Our Case Number: ACP-323851-25

Re: Proposed construction of the Celbridge Hazelhatch Mobility Corridor
Celbridge Town, County Kildare

RE: Celbridge Hazelhatch Mobility Corridor Application, Case Ref: JP09.323851

C01

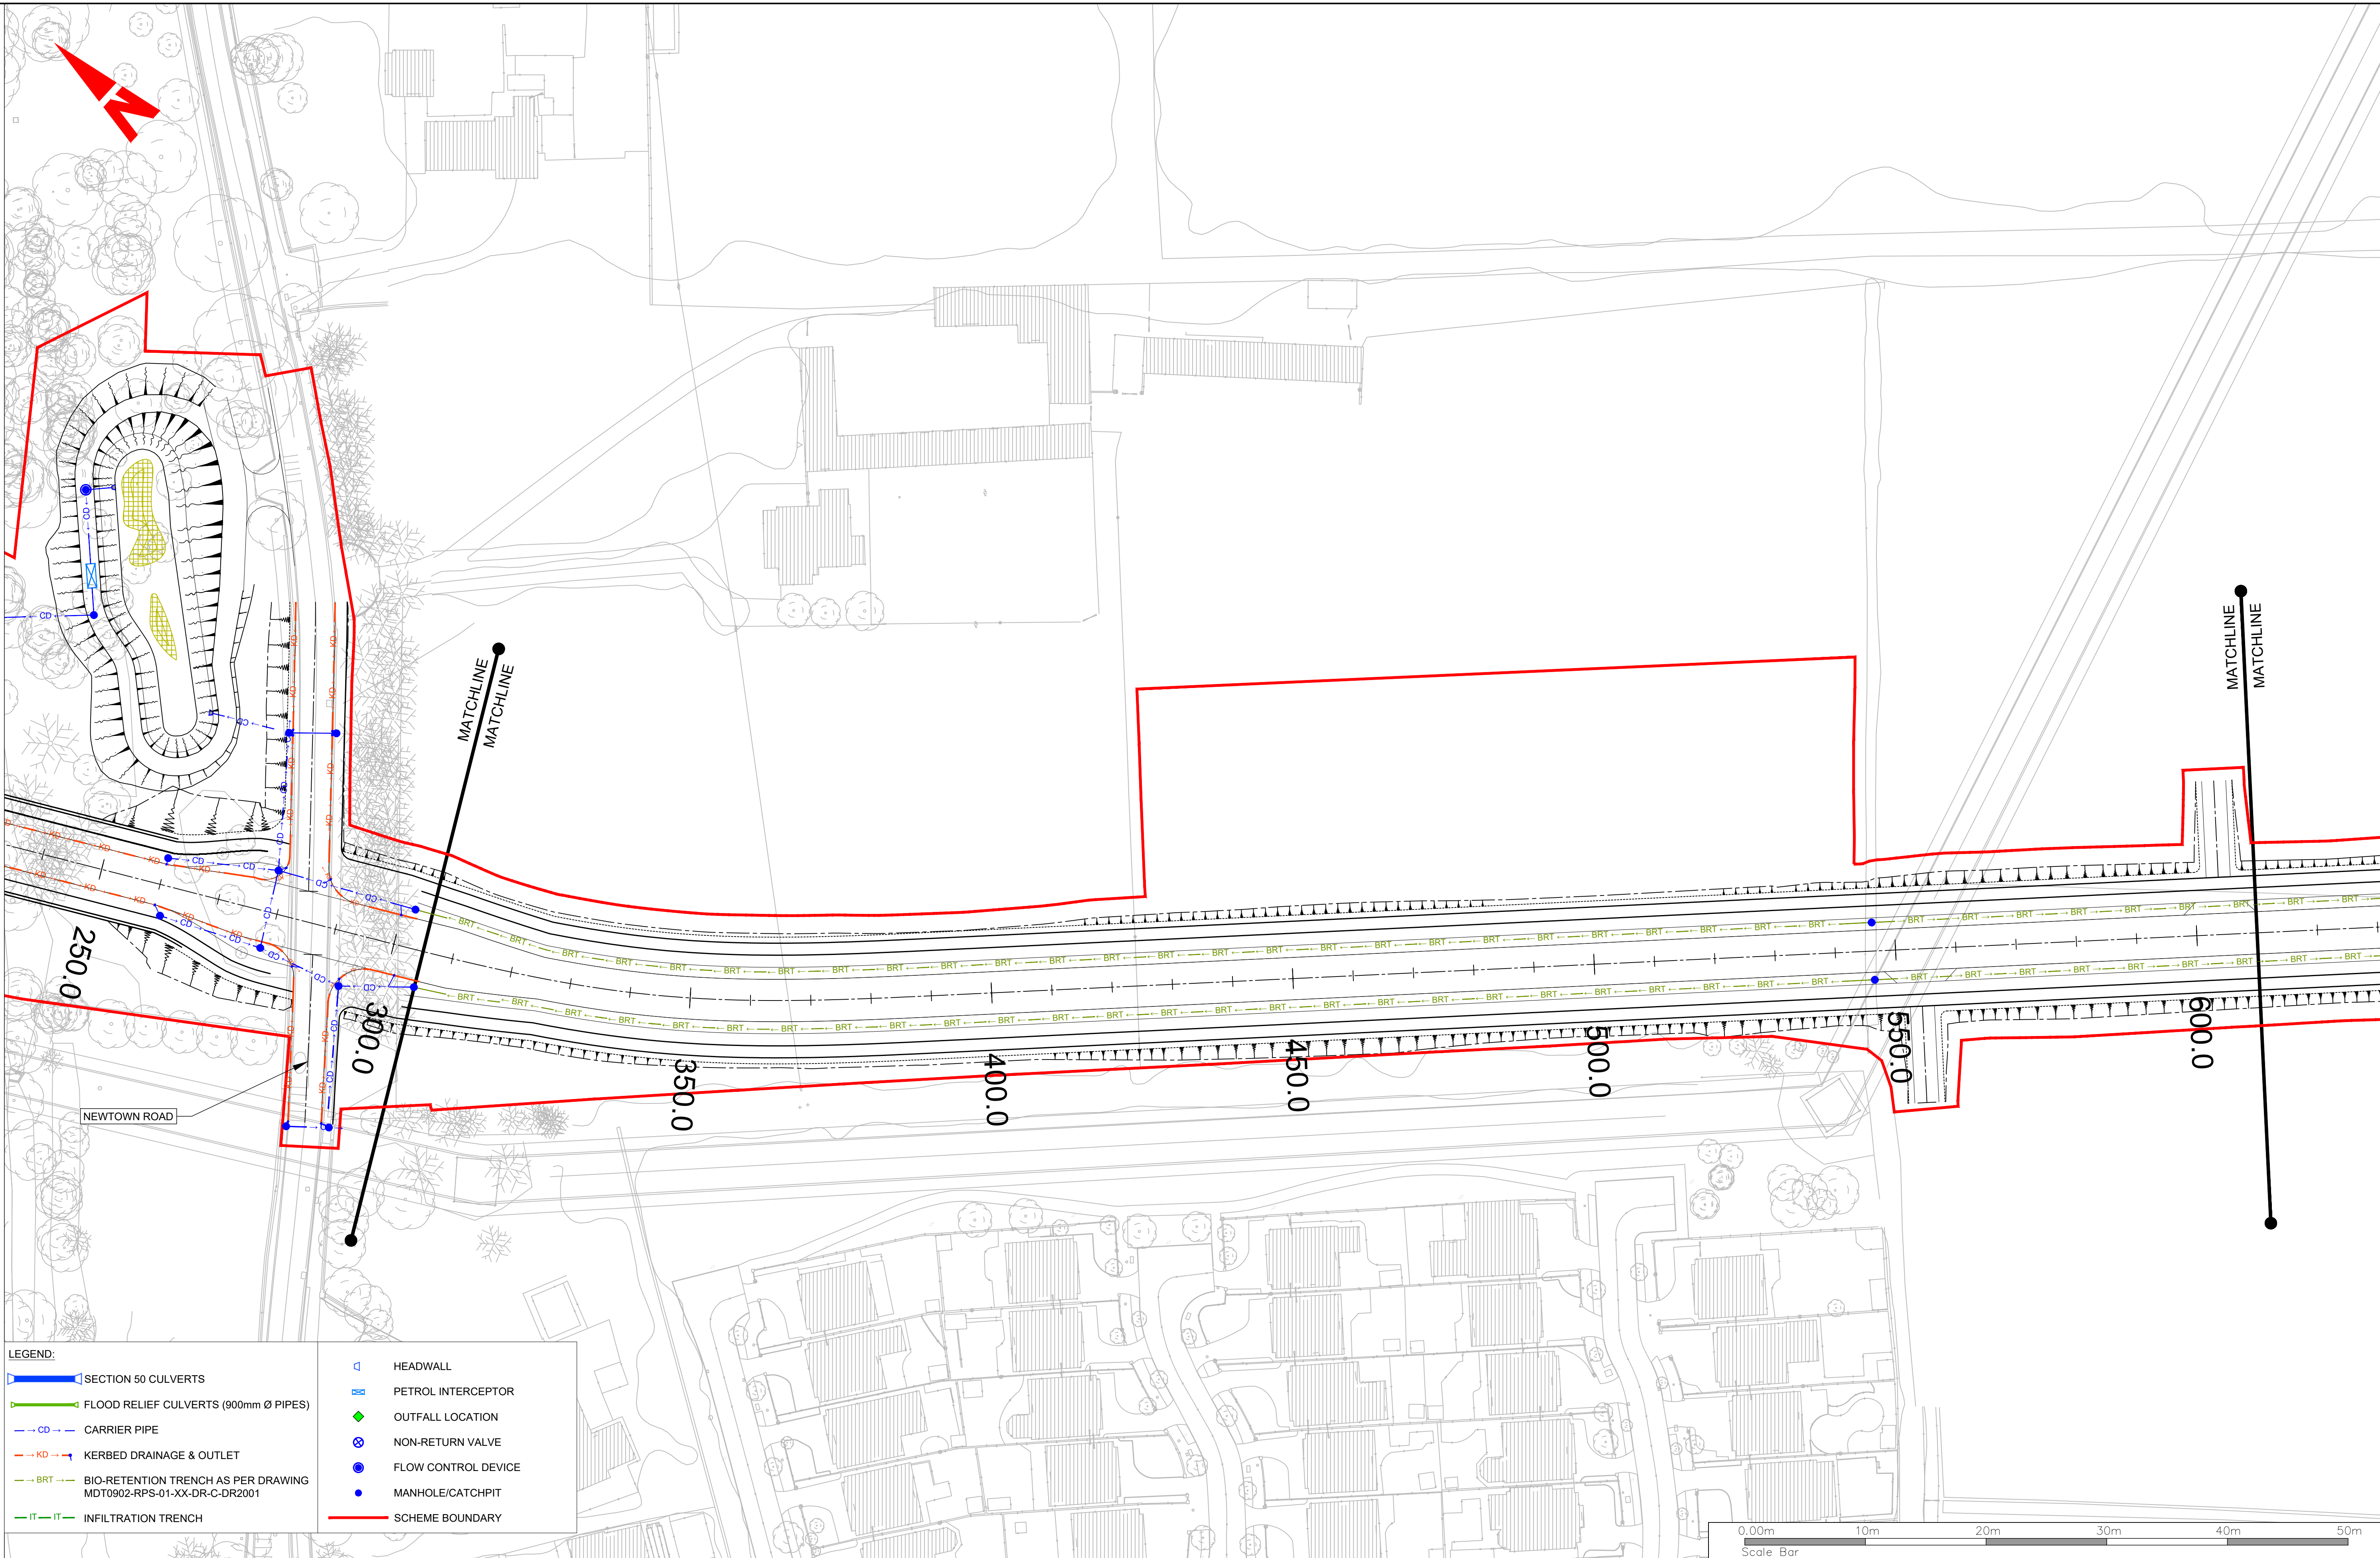
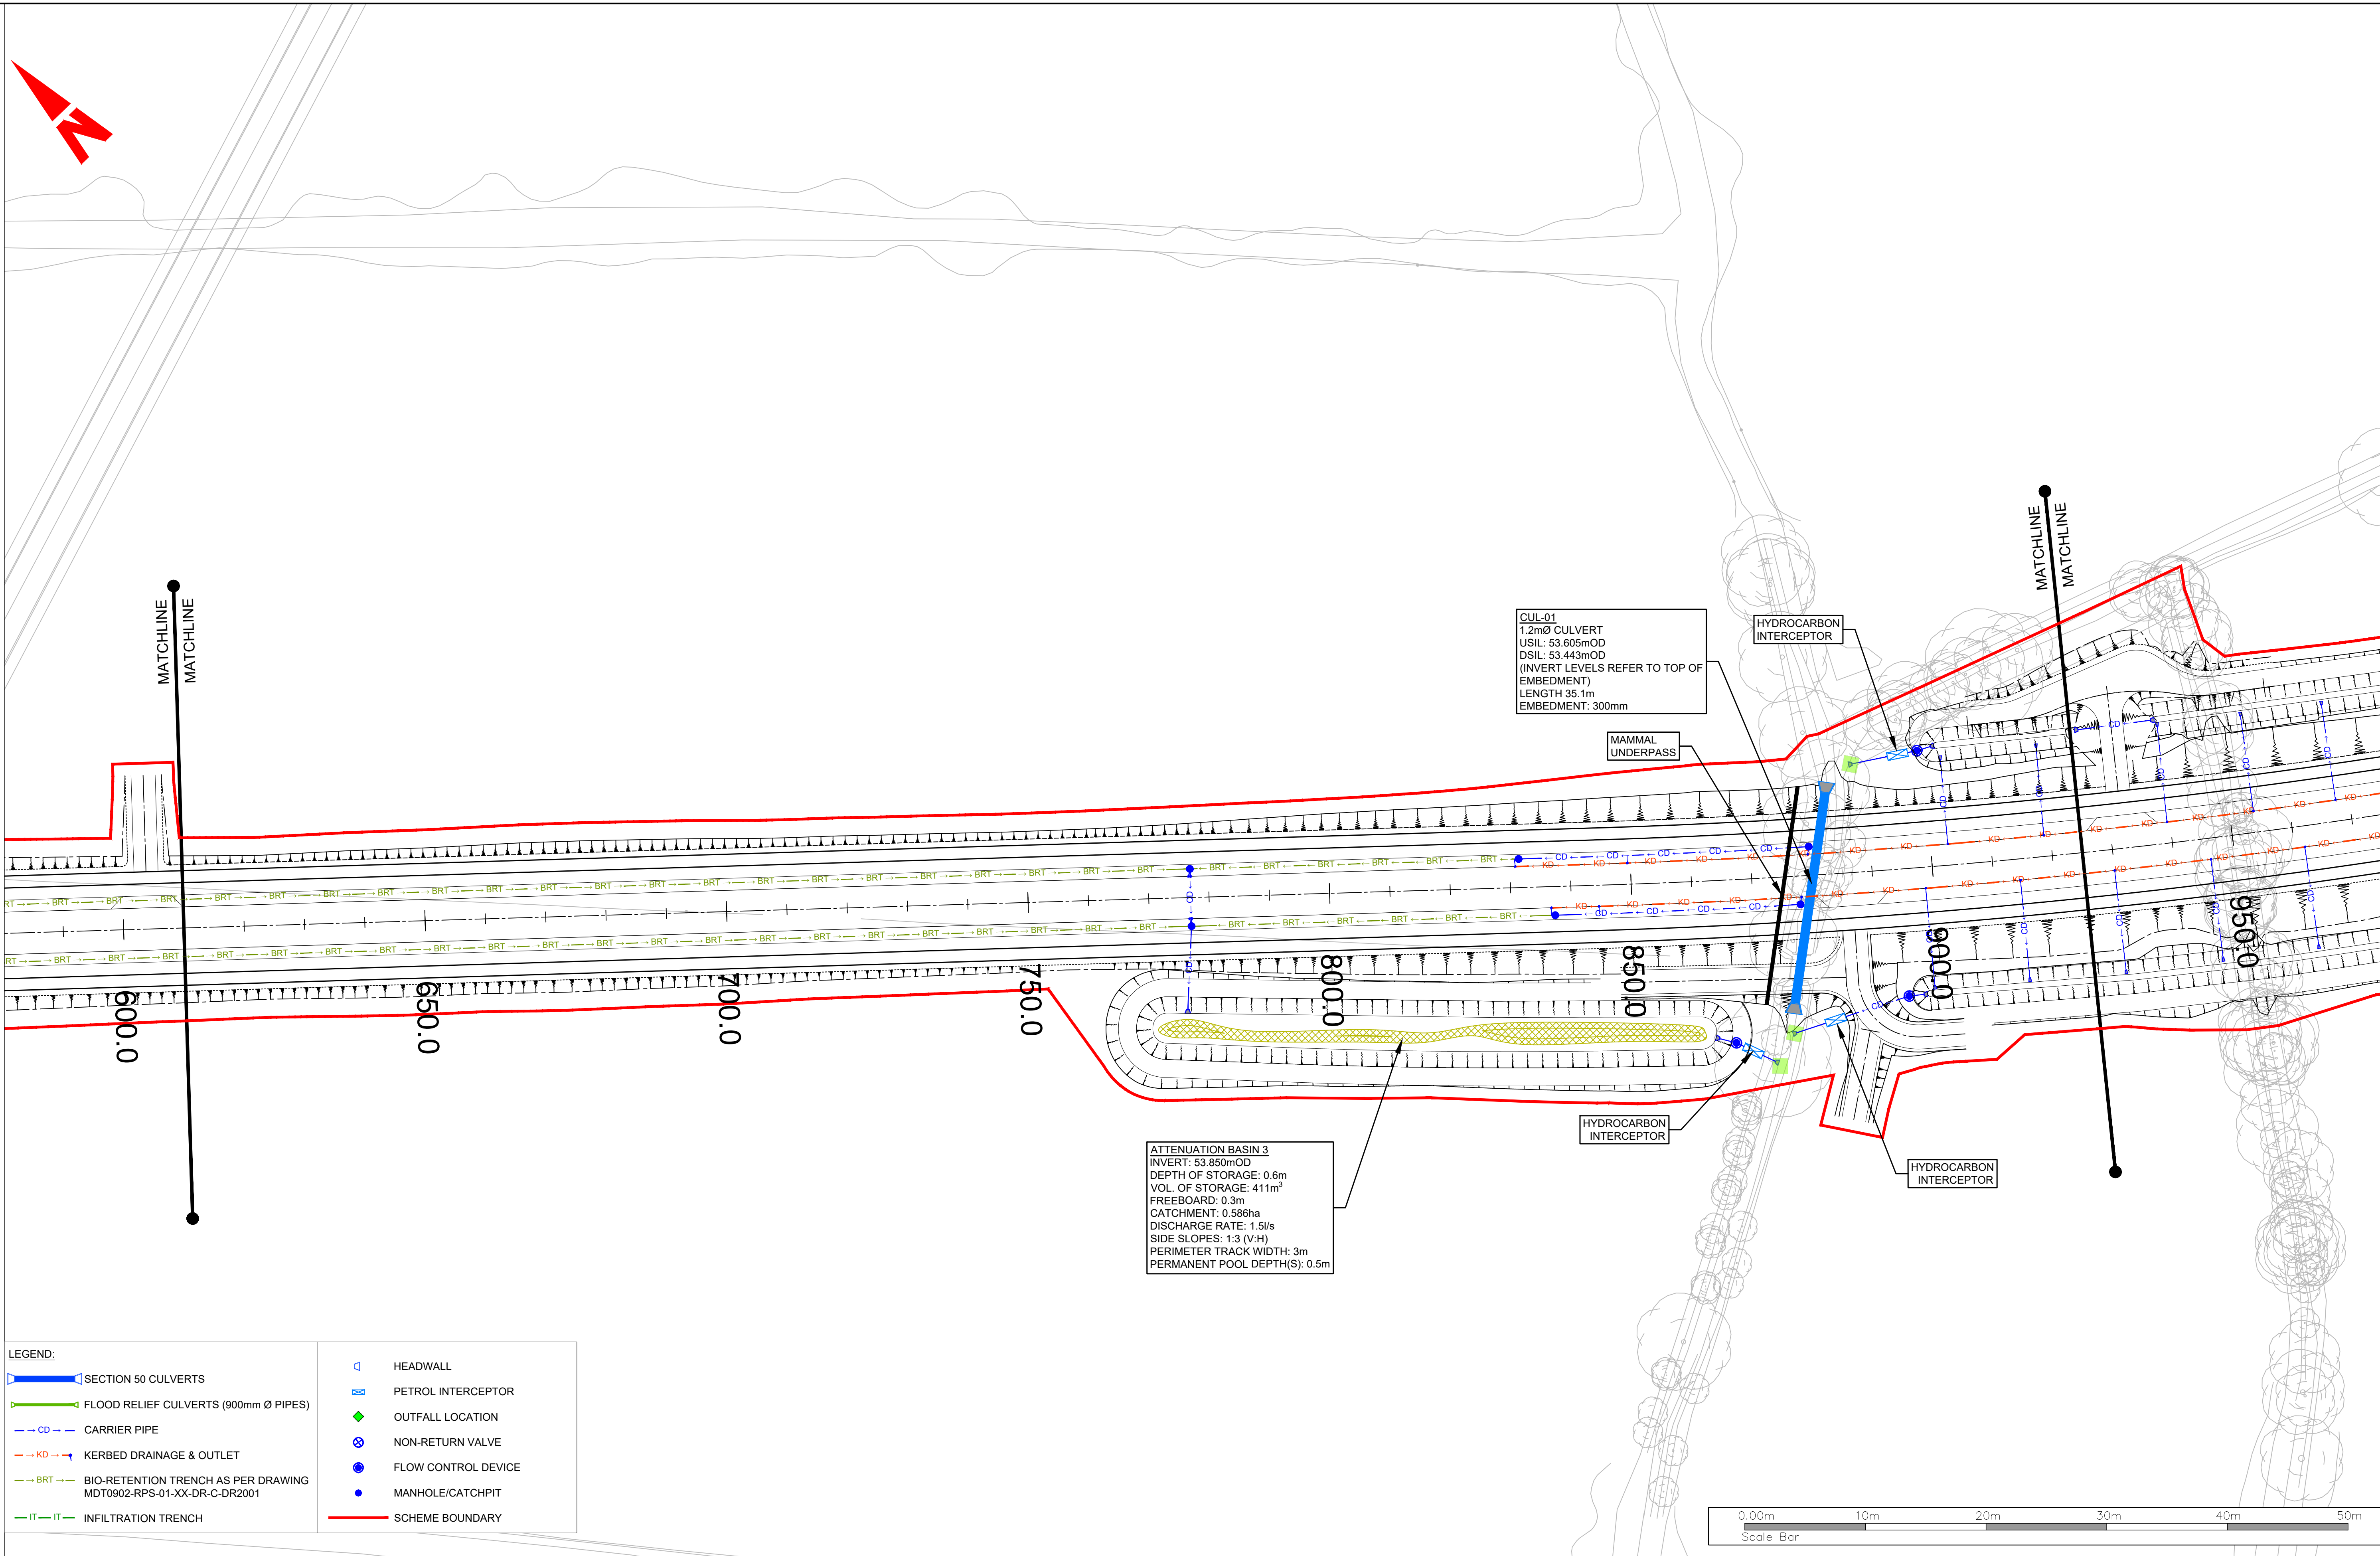
It is our opinion that the stormwater management strategy for the Mobility Corridor, incorporating linear stormwater channels and storage features, should be reviewed so as not to impact adjacent proper development. The current design has swales on both sides of the corridor. This is not conducive to a streetscape and should be reconsidered.

There are a number of attenuation basins and swales located on both sides of the Mobility Corridor. While it is acknowledged that these features are necessary for the construction of the Mobility Corridor, it is suggested that their layout and extent be reviewed in light of their potential impact on future residential development frontages. As currently proposed, the location of the basins and swales would push back potential residential building lines from the road edge, in some instances by up to 20m.

In this context, the current extent and positioning of the proposed attenuation basins and swales along the Mobility Corridor may conflict with DMURS principles by increasing the separation between the carriageway and future development plots. This could result in recessed building lines, reduced enclosure and a diminished opportunity to deliver active frontages along the corridor. A review of the layout, scale, and continuity of these features is therefore suggested to ensure alignment with DMURS objectives and to support the creation of a legible street that balances movement with placemaking.
